Kirklees Highways Development Management comments

2021/62/92086/W – Erection of 270 residential dwellings and associated infrastructure and access

Land at Bradley Villa Farm, Bradley Road, Bradley, Huddersfield, HD2 2JX

INSET: A641 BRADFORD ROAD SHARED FOOTWAY/CYCLEWAY
SCALE 1:250

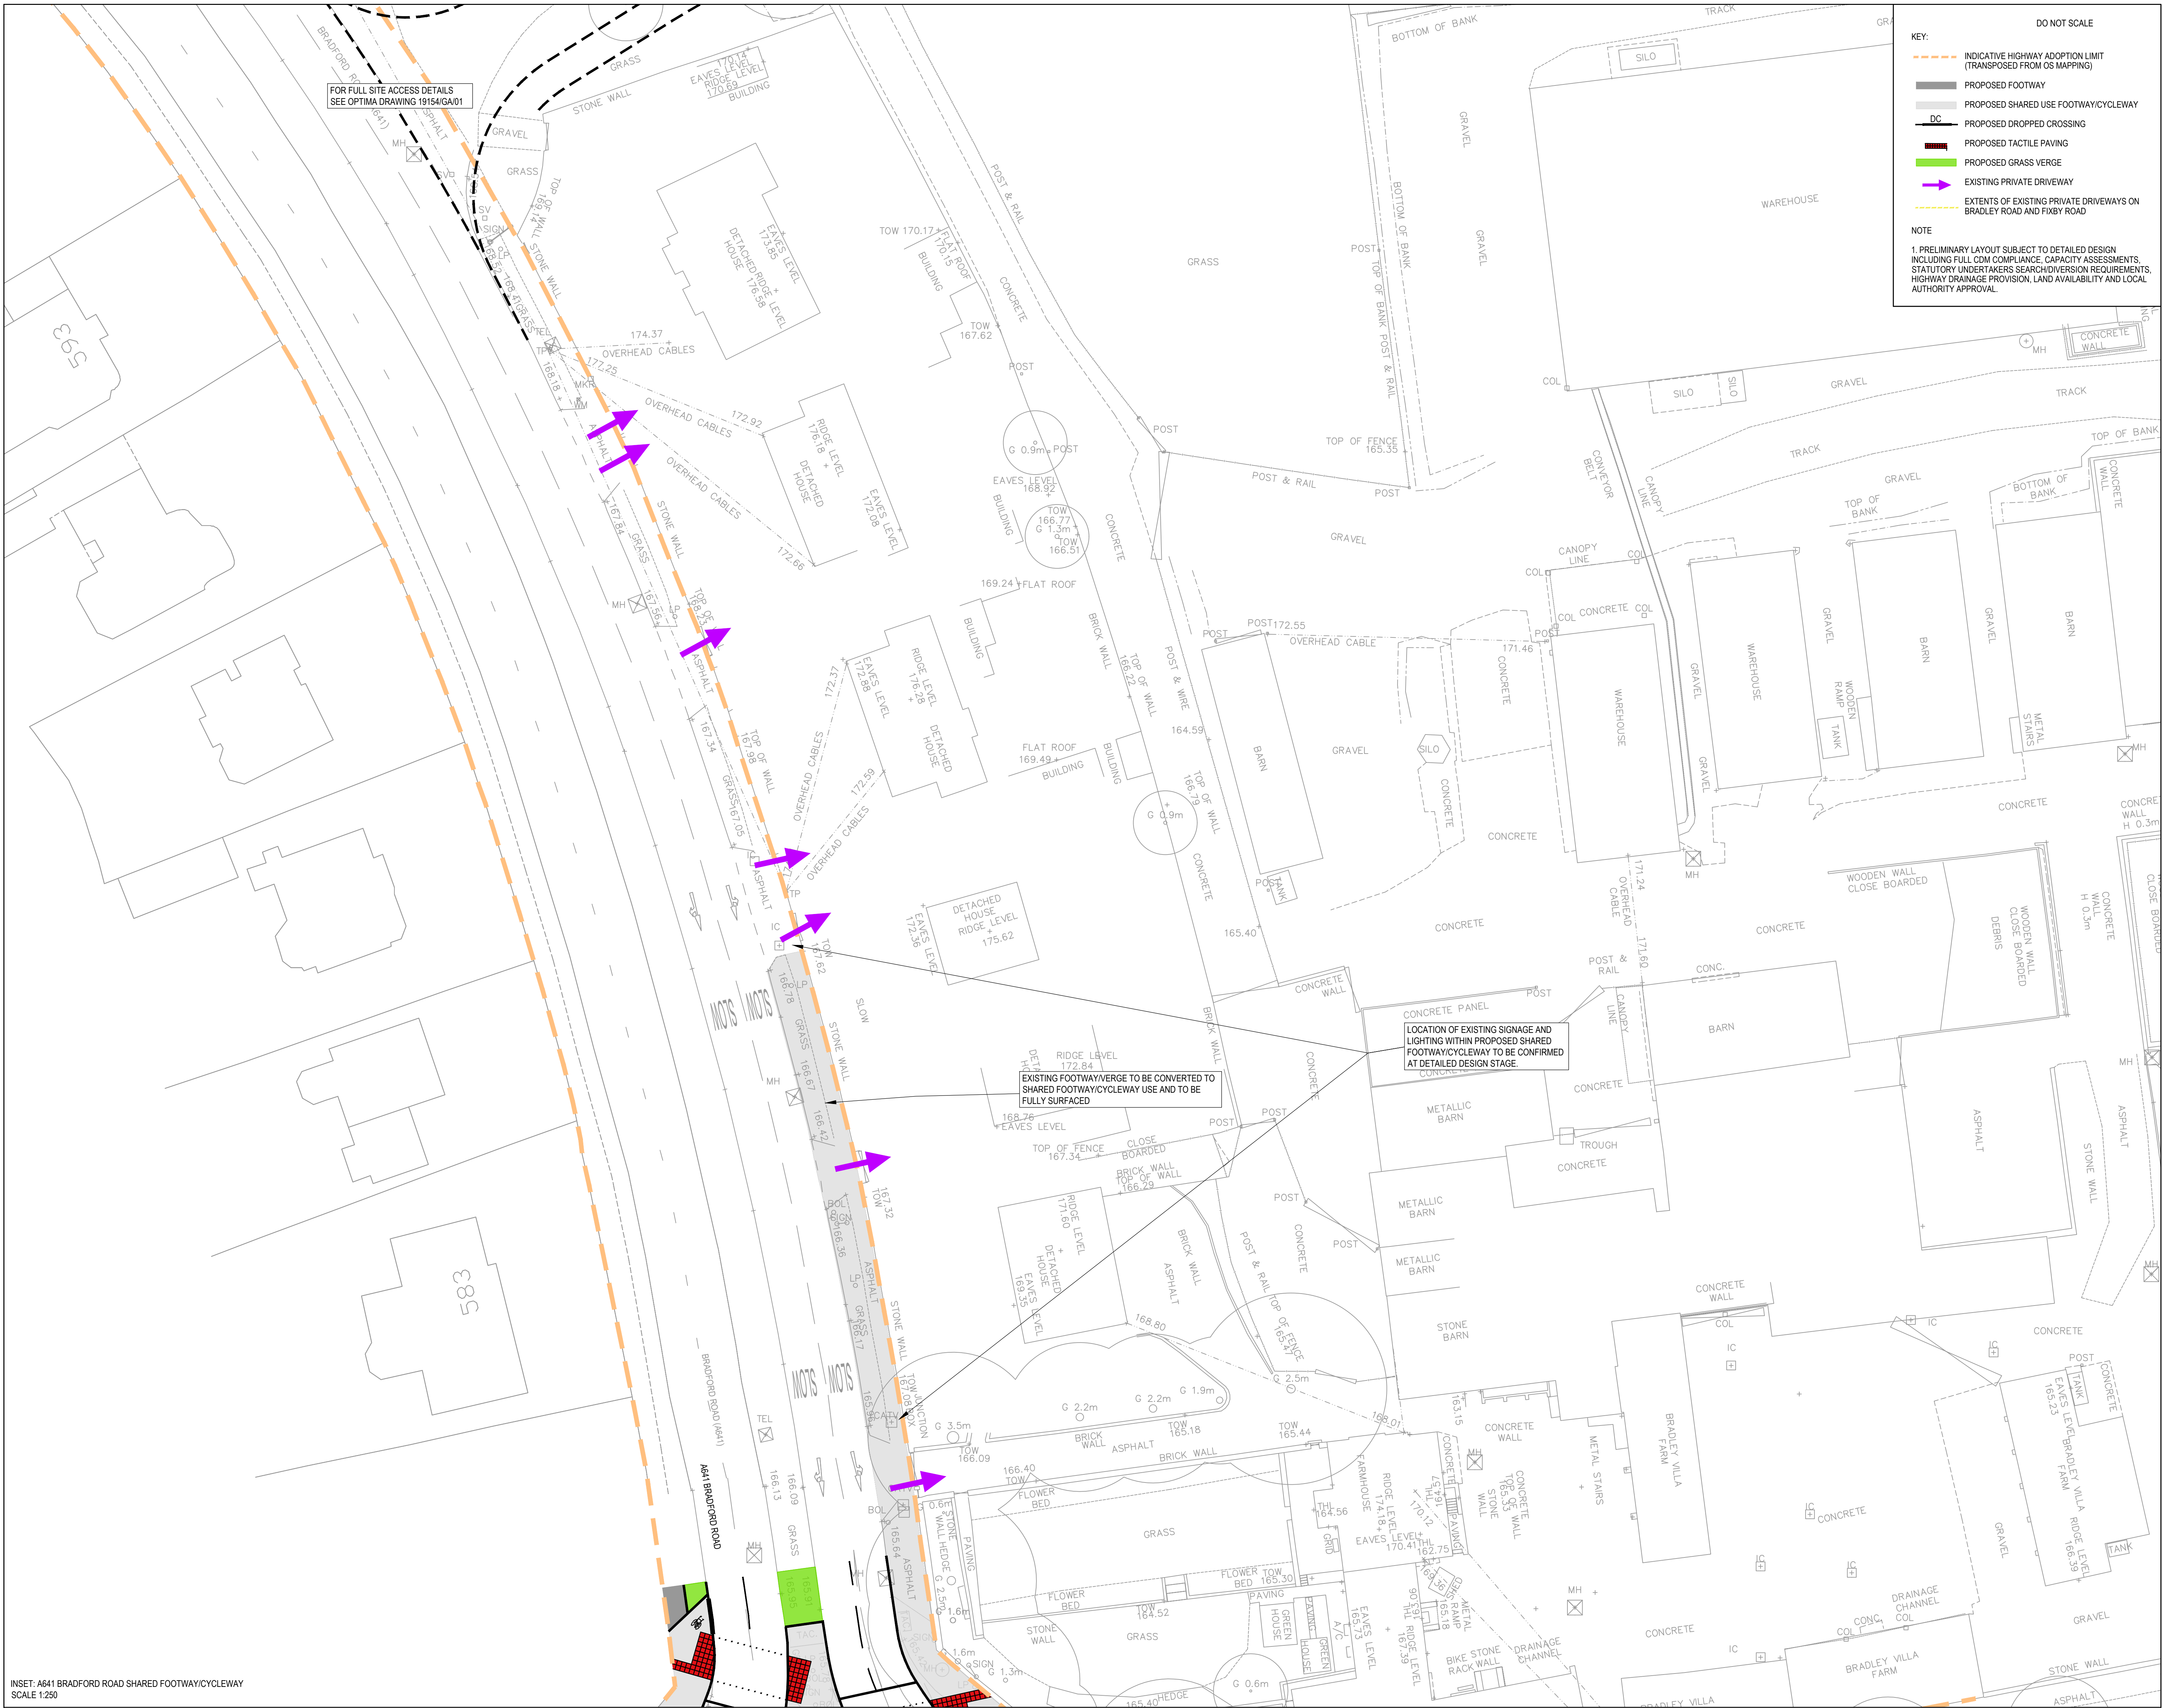
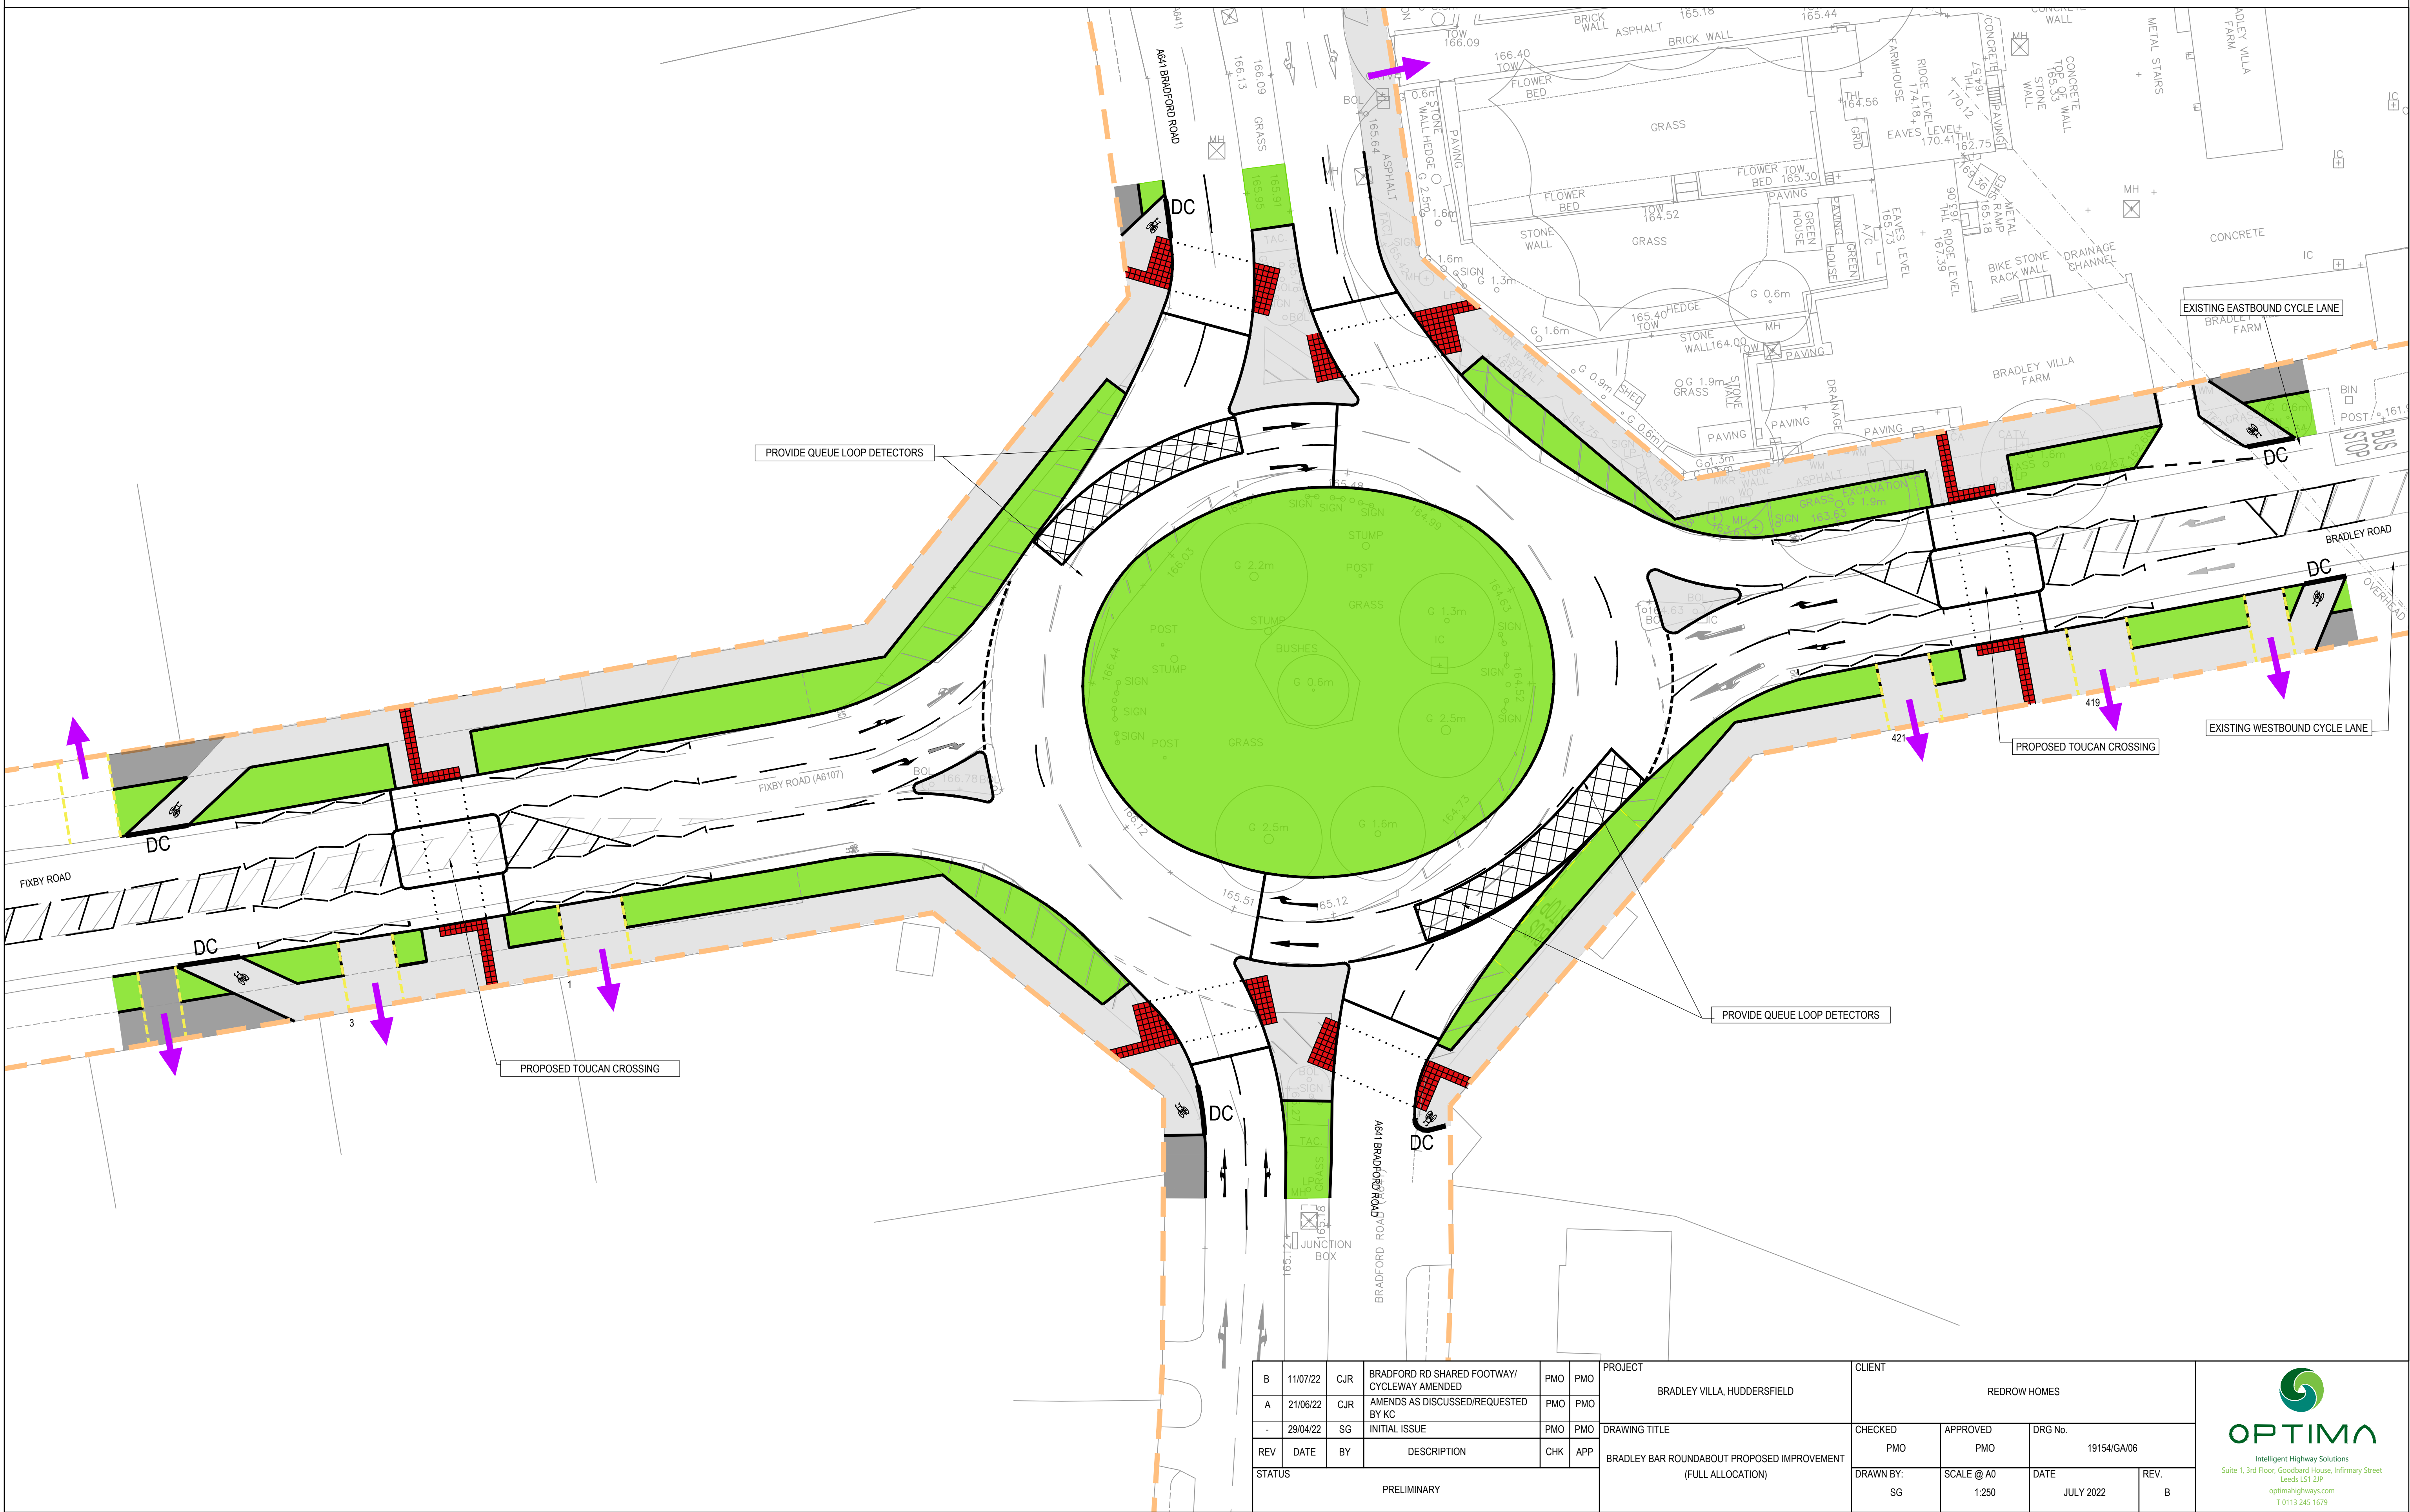
Kirklees HDM is concerned at the lack of existing (or proposed) formal pedestrian crossing facilities on the A641 Bradford Road. This is formed of a 40mph road with 2 north-bound lanes and 2 south-bound lanes.

Passengers alighting buses at the north-bound bus stop would have to cross 4 lanes of (40 mph) traffic. They may be weighed down with shopping bags, have small children to hold onto, using a pushchair or be disabled and reliant on a mobility scooter. There are serious concerns that vulnerable road users would be at serious risk when crossing the A641, particularly in low light or inclement weather conditions.

HDM has concluded that the provision of dropped kerbs and tactile paving (with a central refuge) does not form mitigation that sufficiently addresses these concerns. It is therefore requested that the application team explores the provision of a signal-controlled pedestrian

crossing at a suitable location that facilitates a pedestrian desire line between the site access and the north-bound, Bradford Road bus stop.
